Ribble Valley Borough Council
Housing & Development Control

Application no: **3/2024/0061**

Address: **Land Adjacent to Ferns Northcote Road Langho BB6 8BG**

Proposal: **Approval of details reserved by conditions 7 (Desk Study), 8 (Foul and surface water drainage scheme), 9 (Construction Management Plan), 10 (Bat and bird boxes), 12 (Landscaping), 13 (New footway and dropped kerb access), 15 (Management and maintenance of estate road), 16 (Internal estate roads) of planning permission 3/2022/0537.**

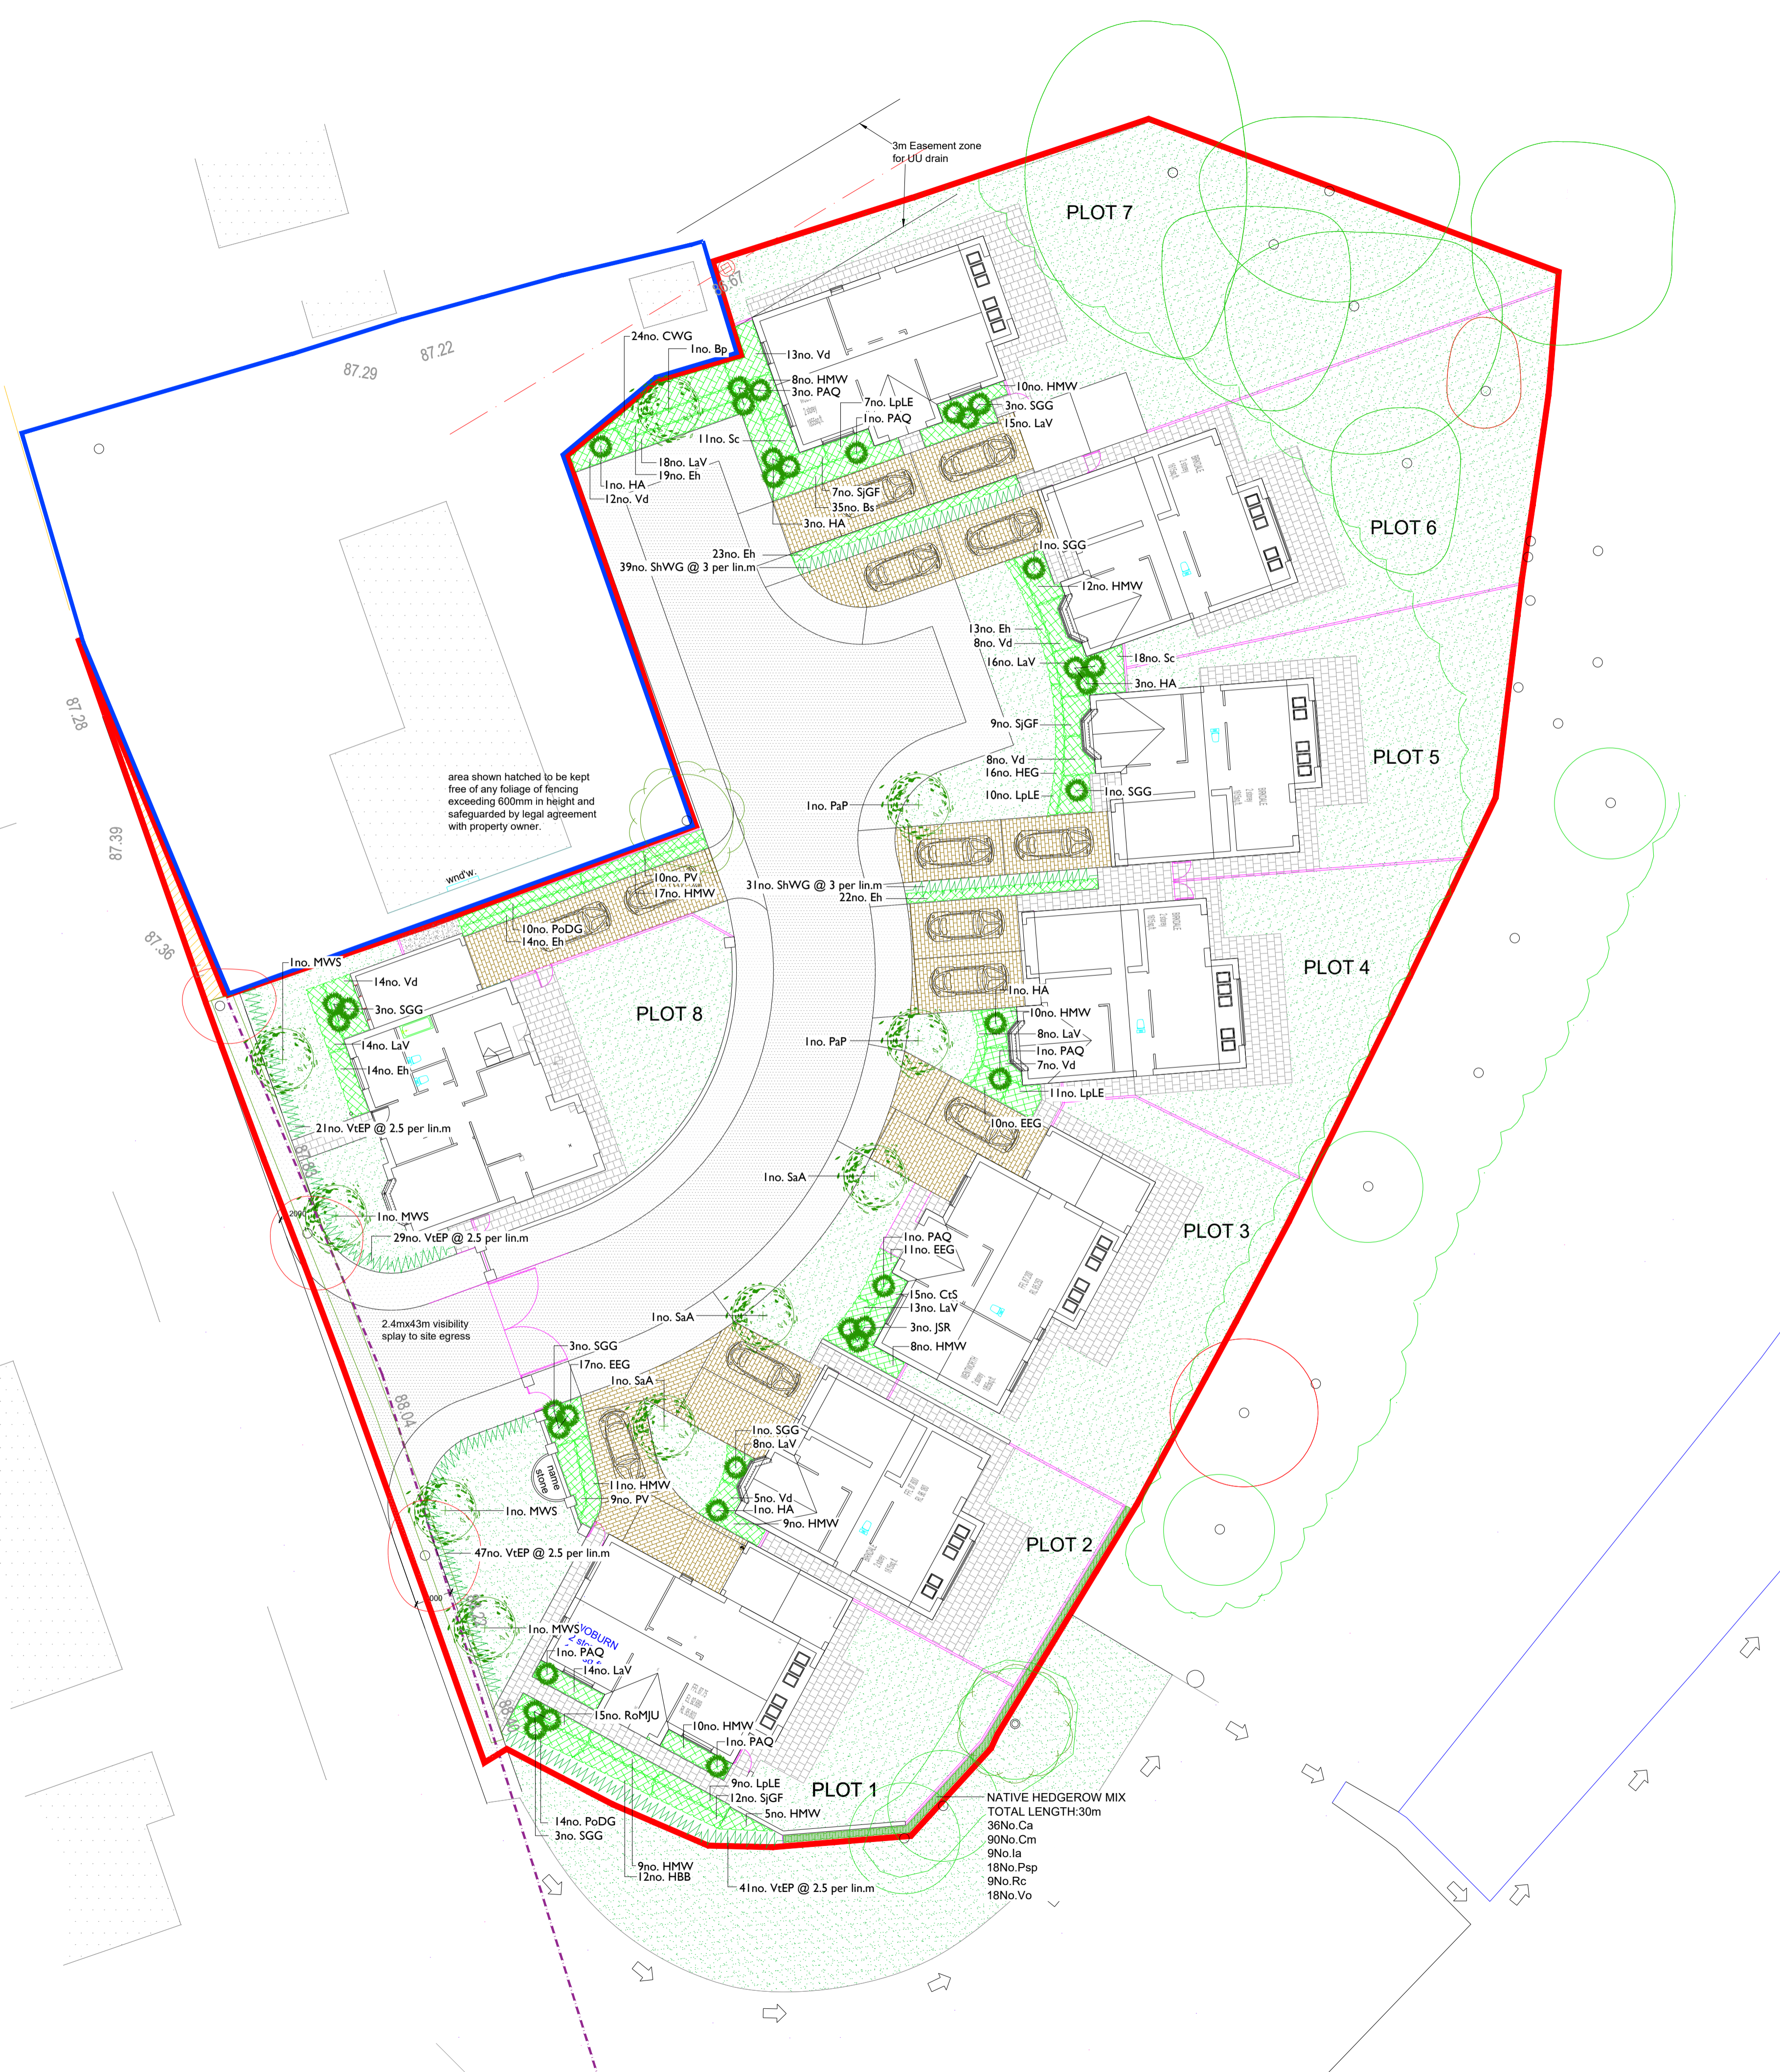
The LHA have reviewed DEP drawing number 04 Rev A titled "Landscaping Plan" and object to the discharge of condition as presented. This is because the LHA require the trees located within the sites visibility splays to be pushed further into the site to prevent any obstruction to the splays. Therefore, a revised plan is required.
